Erection of 2 No 3 bed dwellings with off-road parking and associated landscaping
Land at Entrance to Waterford Gardens Horsemere Green Lane Climping

Thank you for your internet representation made on 2nd June 2019 which has been recorded as '**an objection**' with the comments as follows:

Planning Application CM/18/19/PL -

drawing title:
Site Plan

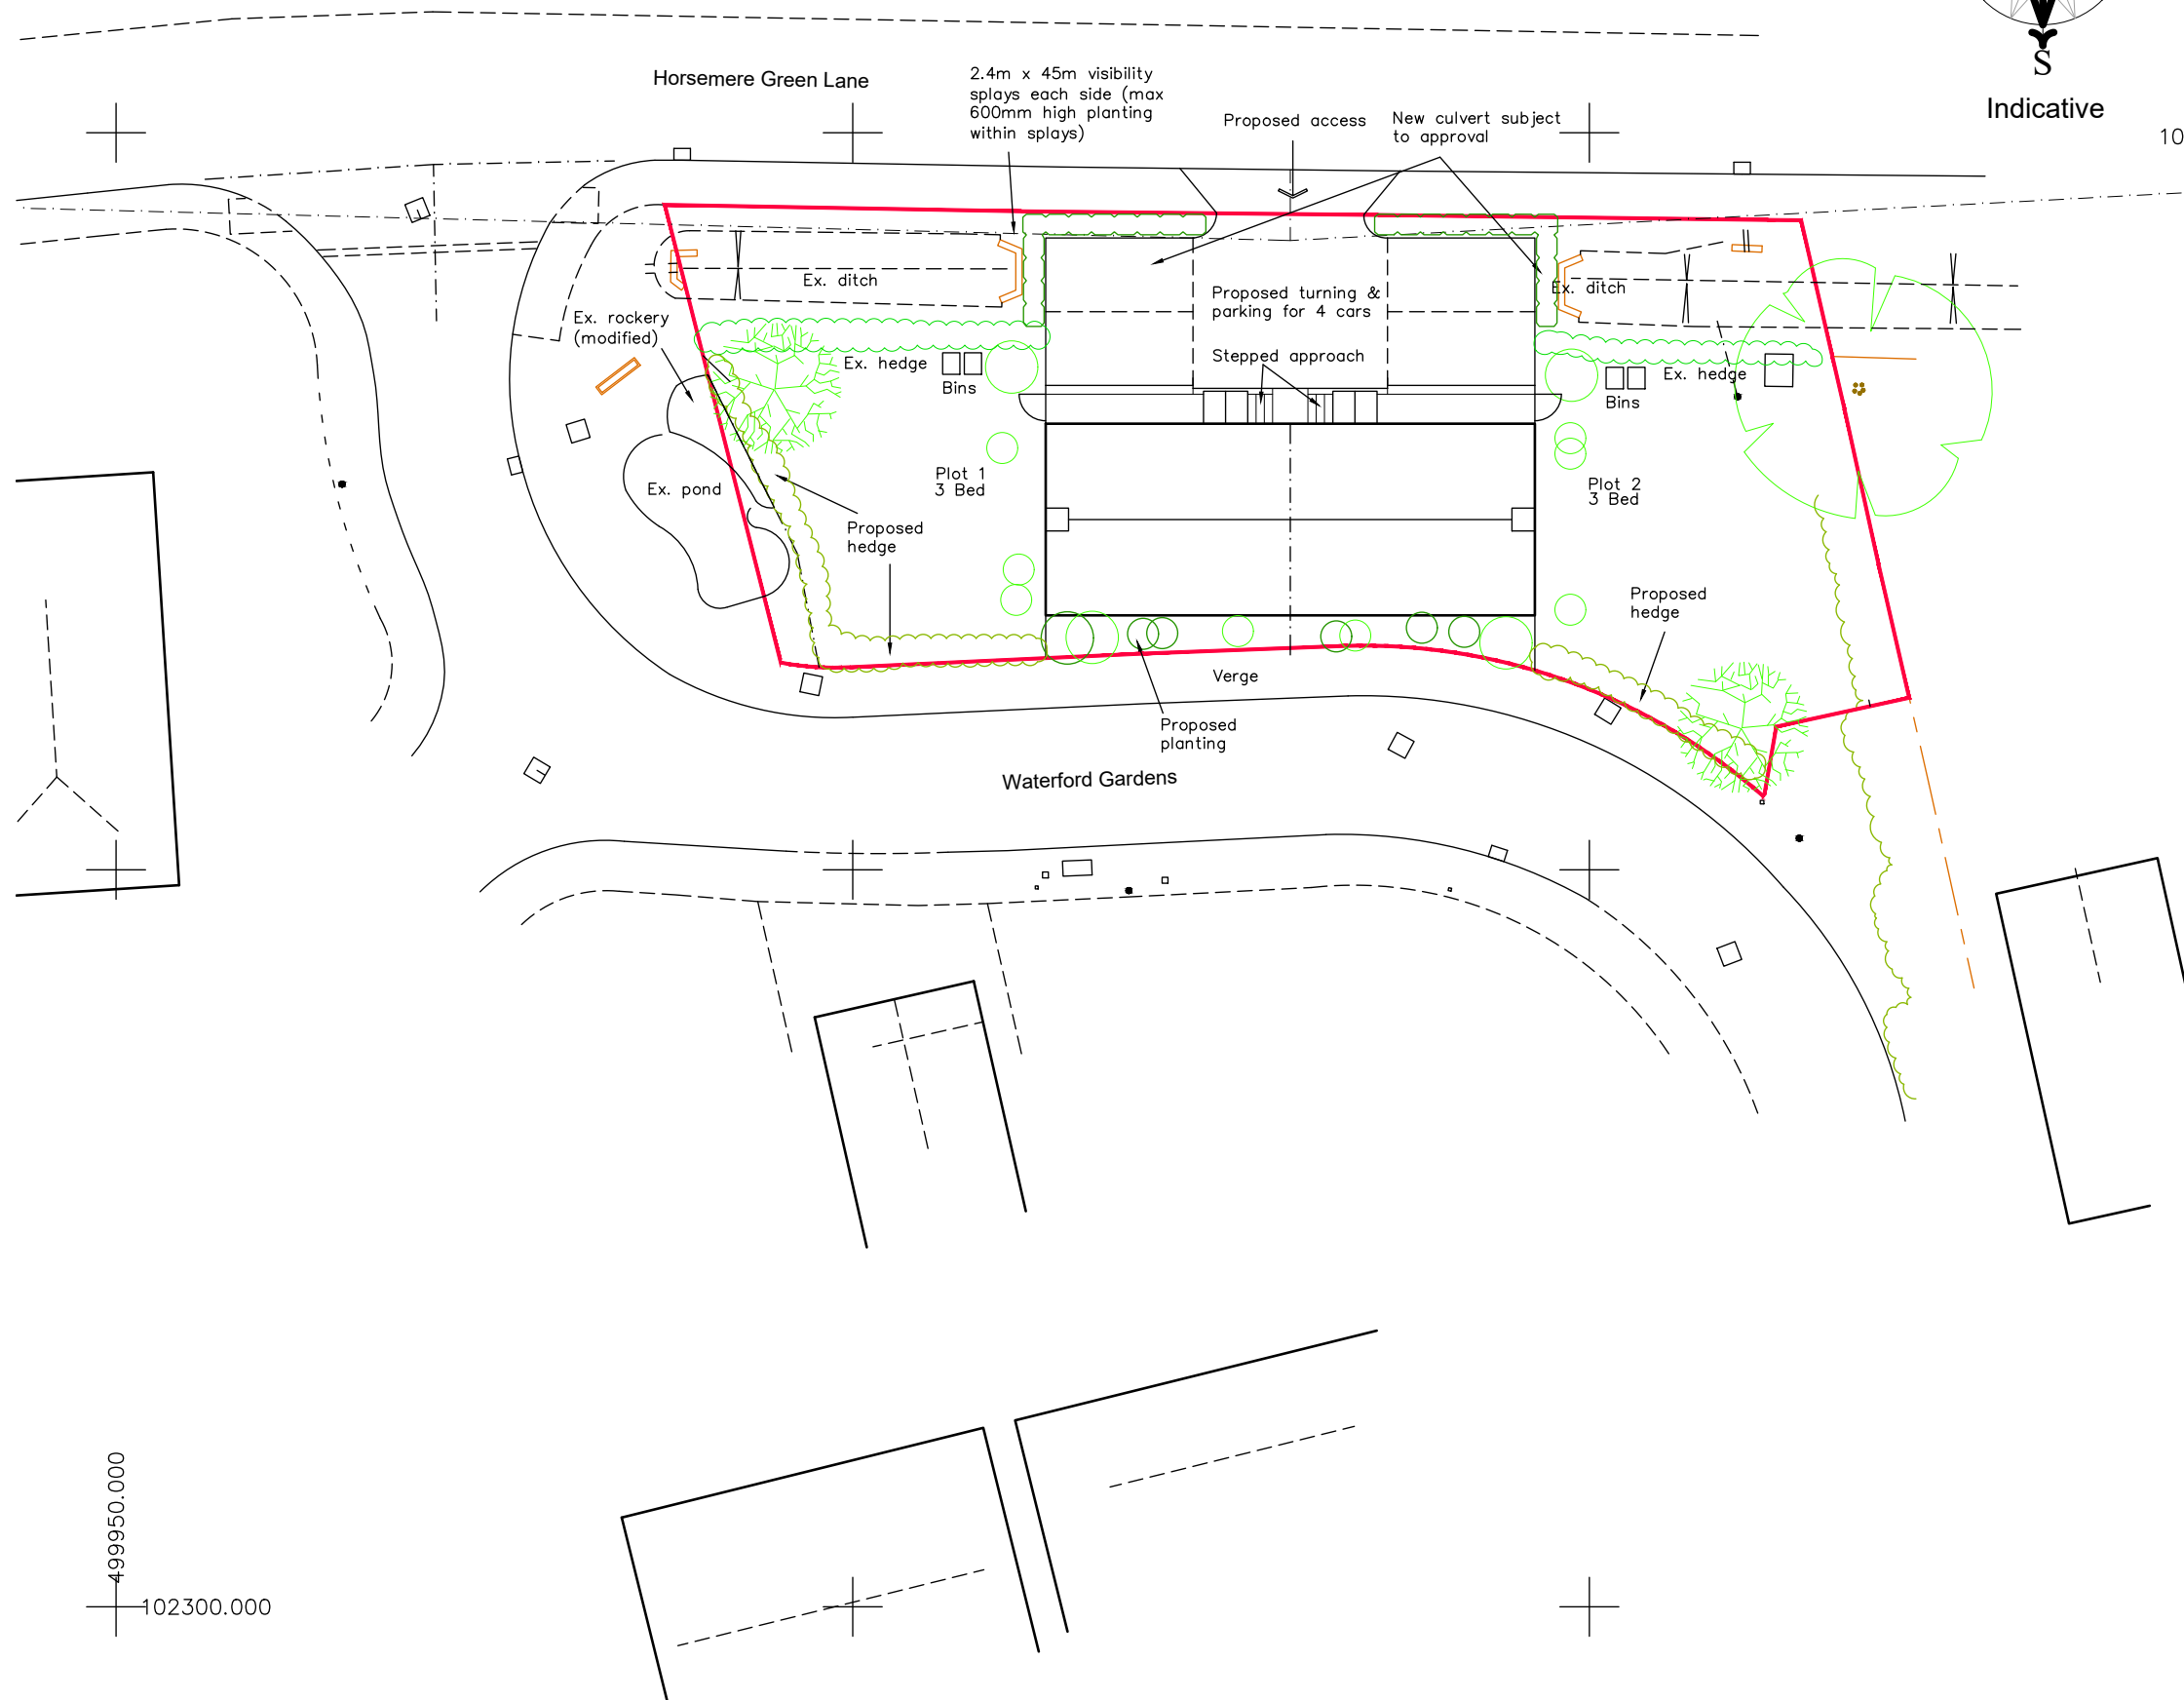
If there are two (2) parking spaces for each plot between HGL and the dwellings then the houses will be so small.

In the event that all four parking spaces are occupied they will have insufficient room to manoeuvre which will result in reversing out into Horsemere Green Lane.

There is a significant height difference between the ground level of the plot and the footway, which is presumably where the driveway will pass over.

It might also be argued that this drive way is rather close to our entrance and potentially dangerous. I don't know if driveways are allowed adjacent to a road junction.

The block plan appears to show the site of plot 1 infringing on the existing pond and landscaped area which are in the ownership of the estate, so this needs rectifying.

There are three manholes covering 'soakaways' 1.8 metres from the kerb line. This was previously agreed to be laid out as a footway, shown on the previous plans. There are also other services supply power to CCTV, pond pumps and street lighting (private)

In conclusion I can only say that to have a driveway across the front of our estate will destroy a beautiful Laurel hedge that was funded by the Waterford Gardens residents. It will also become a blemish on the view of HGL.
